December 29, 2015  
15198

**Site Plan Level 1 Application Plan Revisions and Responses per Staff Review Comments  
Maine Fiber Company Switching Facility & Equipment Shelter;  
9 Westland Avenue, Portland, Maine**

SHEET TITLE:
COMPOUND PLAN

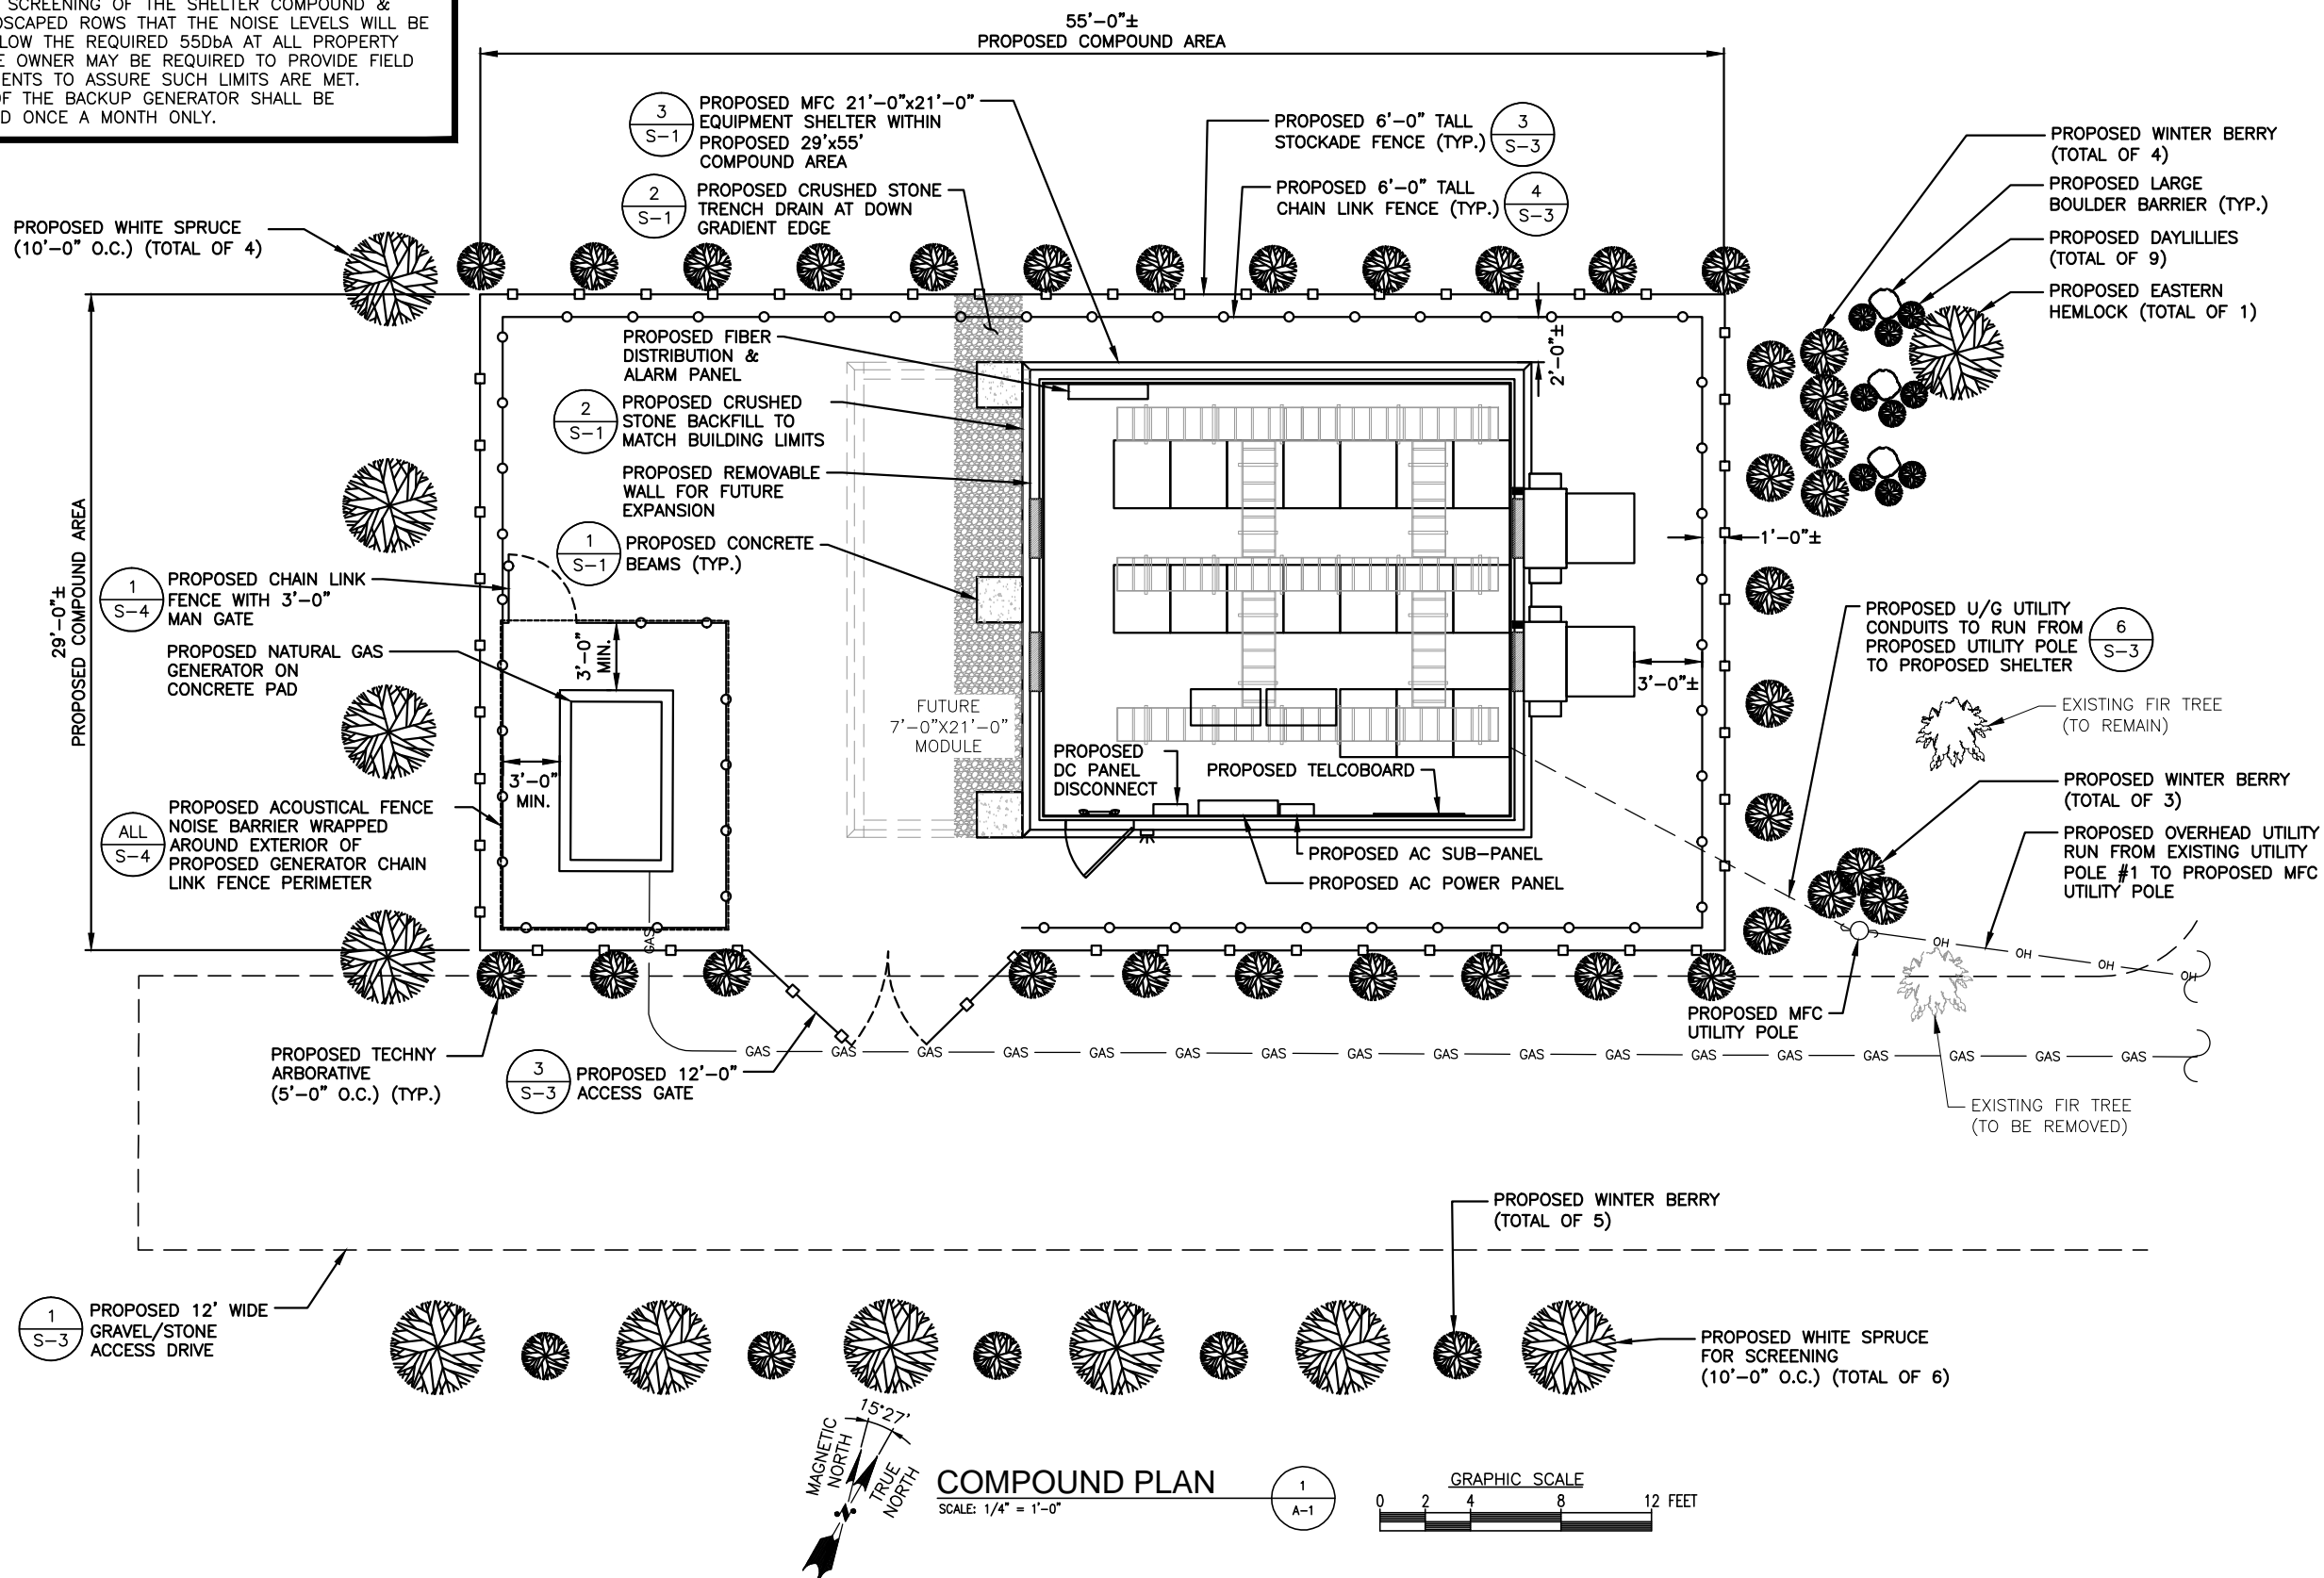
- We eliminated the propane tank and will now utilize natural gas service from Westland Avenue.
- We have provided HVAC Modular Sound Attenuator to the air handlers which will reduce DbA by 20 to have them below Zoning Standards of 55DbA.(Now will be 50 DbA @ front property line)

- We have provided Generator noise levels meeting the same level of DbA at the property line for the parcel to the south and near the same level (Please note these levels are based on open hard scape surfaces, and with wood fence enclosure and landscaping it can be expected to reduce the DbA by 8-10 DbA which is less than a lawn mower from 30 feet. (The generator will be tested only once a month for a max of one hour)

- We have added a note regarding the waiver of the granite curbing requirement
- We have added notes about the backup generator and HVAC units operable noise levels and generator hours of testing.

SHEET TITLE:
**EROSION CONTROL, FENCE,
& MISC. DETAILS & NOTES**

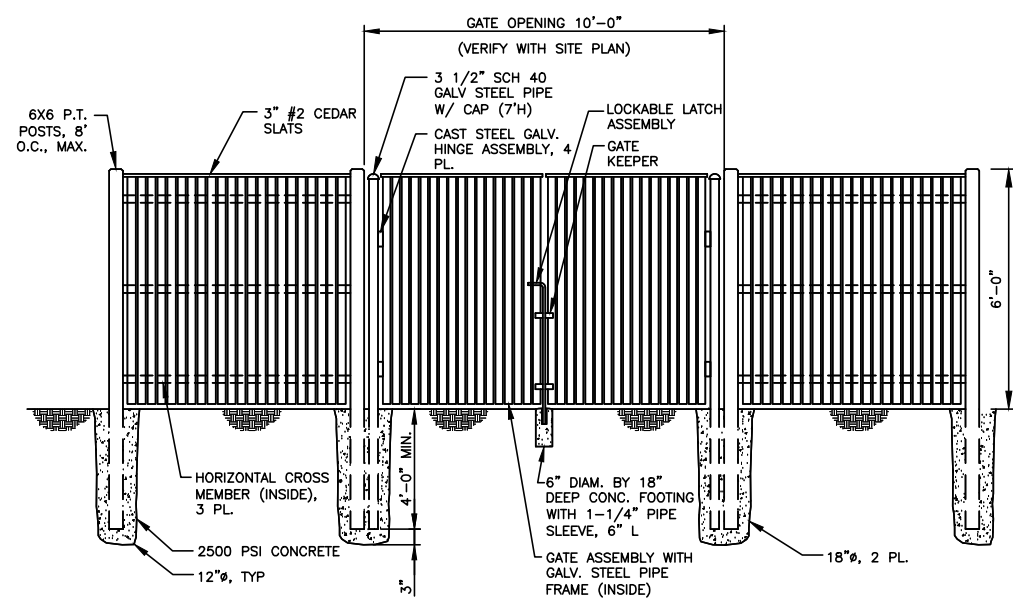
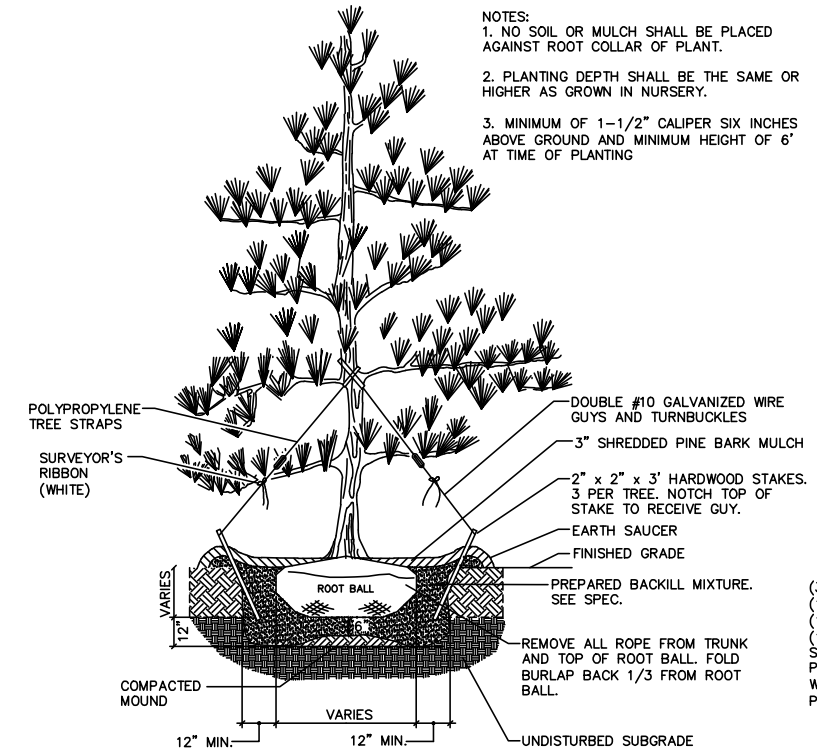
- The 6 foot high chain-link fence will be enclosed with an equal wood stockade fencing material to attach to the outside of the fence for aesthetic purposes.
